Application Correspondence "LPA comments on layout"

From: Simon Davis
Sent: 01 July 2020 11:37
To: [REDACTED]
Subject: BN/50/20/PL Land W of Fontwell Avenue - Design Comments

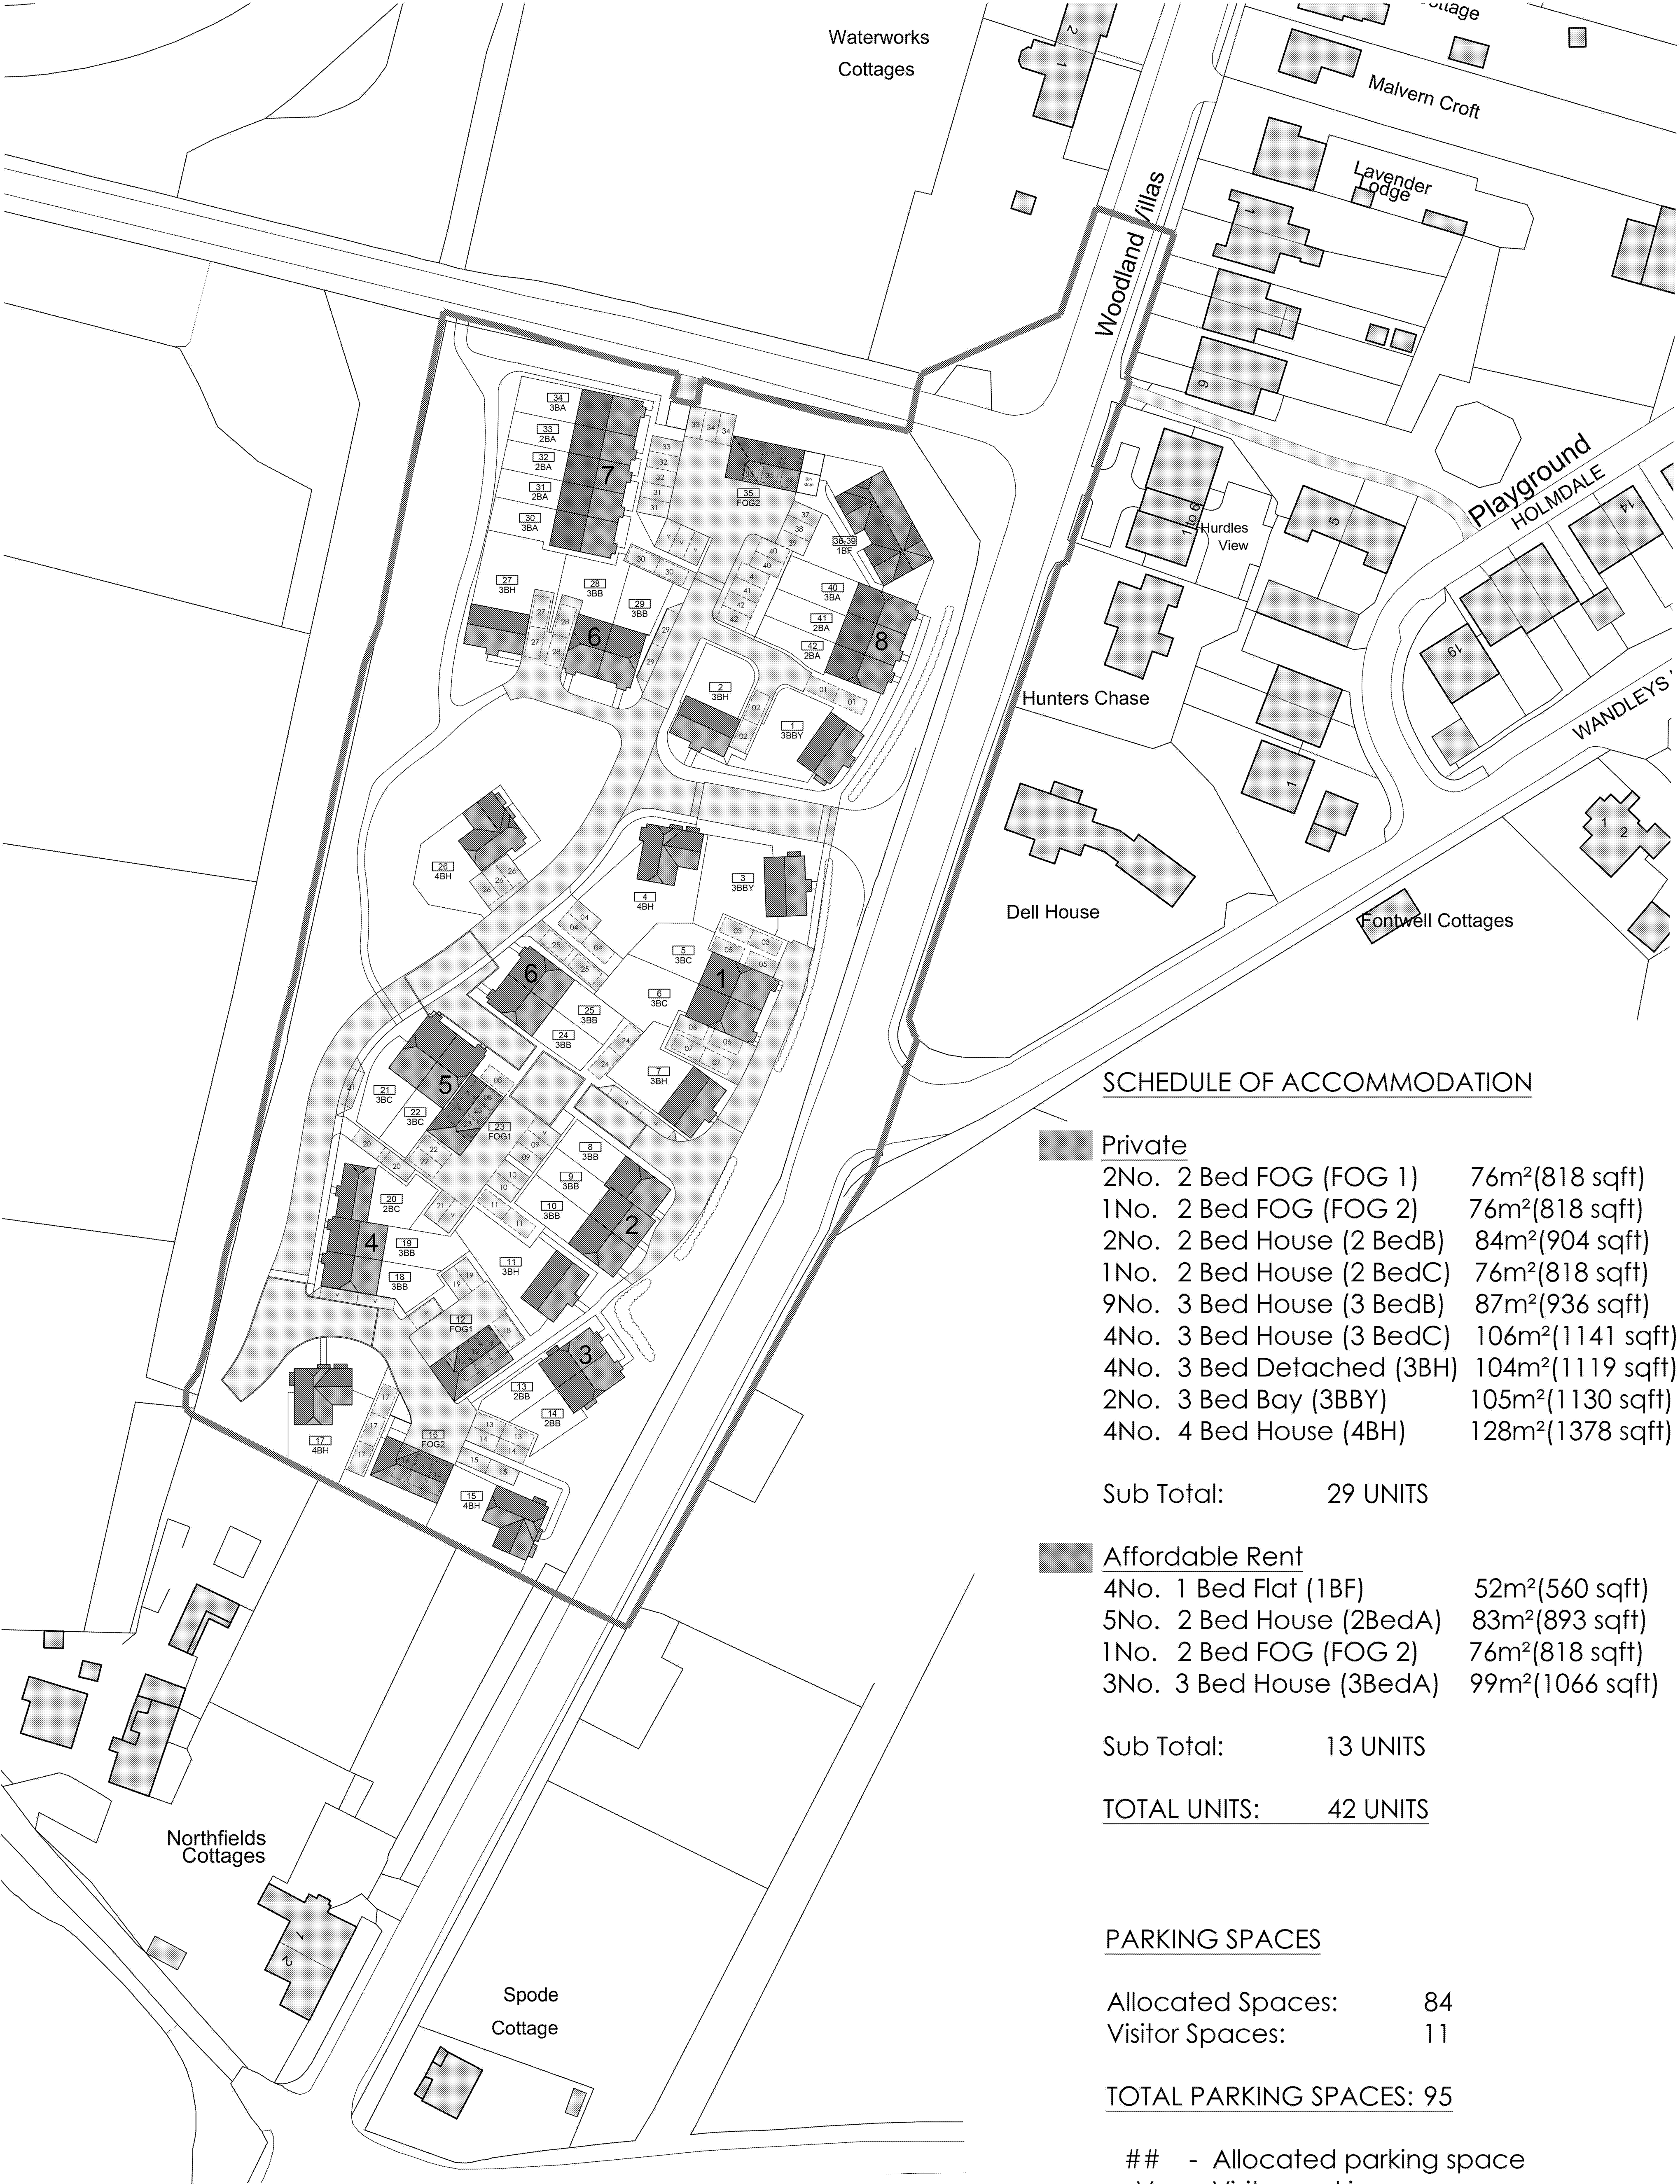
- Many of the residential gardens are not 10.5m in length (as per emerging Arun Design Guide). I have measured some in the range of 8-9m long.
- Plots 12, 16, 23, 35 are first floor only with garage parking below. I don't think these can be termed flats. They seem to have either very little strips of garden or none at all and in all cases do not meet the garden length as per the SPD.

- Plots 36-39 (Flats) don't have enough garden to meet Design Guide (they need either balconies of at least 3sqm of useable space or a residential communal shared space of 40sqm plus 10sqm for each unit (so 80m2 in total).

- The front of plots 36-39 (Flats) look straight onto the garden of house 40. Windows in this elevation are bathroom and kitchen. Whilst we would o/g bathroom windows, and could do the same for kitchens, it's not ideal for future occupiers of the flats and a sense of perceived (fear) of overlooking would remain.

- The rear of house 12 looks straight onto the garden of 13. The 2 x bathroom windows can be o/g and fixed shut (the plans should be updated to reflect this) to remove overlooking but would leave a sense of perceived overlooking which whilst not ideal would be acceptable.

- We have some concerns with the layout in terms of the large frontage parking areas at the northern end. However, if the landscaping along the roads is strong enough, then this will be screened out from the streetscenes. I am not convinced that the landscaping is significant enough and there is also a question as to how long it will take to fully mature.

- The parking proposal vs the requirement is off. Your plans show 66 on plot spaces, 22 garage spaces (note that the schedule Rev L says 18 and I think miscounts the number of garage spaces in plots 12/16/23/35) & 10 visitor spaces. Garages are treated as half a space in the Arun Parking Standards SPD therefore the proposal is 87. The requirement on the other hand is 96. I accept that our policy allows for 10% variation if a Travel Plan is provided and that you have supplied one. However, I'm not convinced that this is sufficient to warrant an under provision particularly given the countryside location. You could swap out the 10 detached garages for car ports and thus gain 5 proposed spaces which would help and may om balance allow this to be overcome. Incidentally, there are no plans that I can see of the 10 single garages. Please provide these or if swapping with car ports then provide plans of those.

- Our Open Space SPD requires 2,957m2 of POS (see calculator on this page: <https://www.arun.gov.uk/supplementary-planning-documents-spd#openspaces>). Your proposal is only 1,488m2 and this represents a big shortfall.
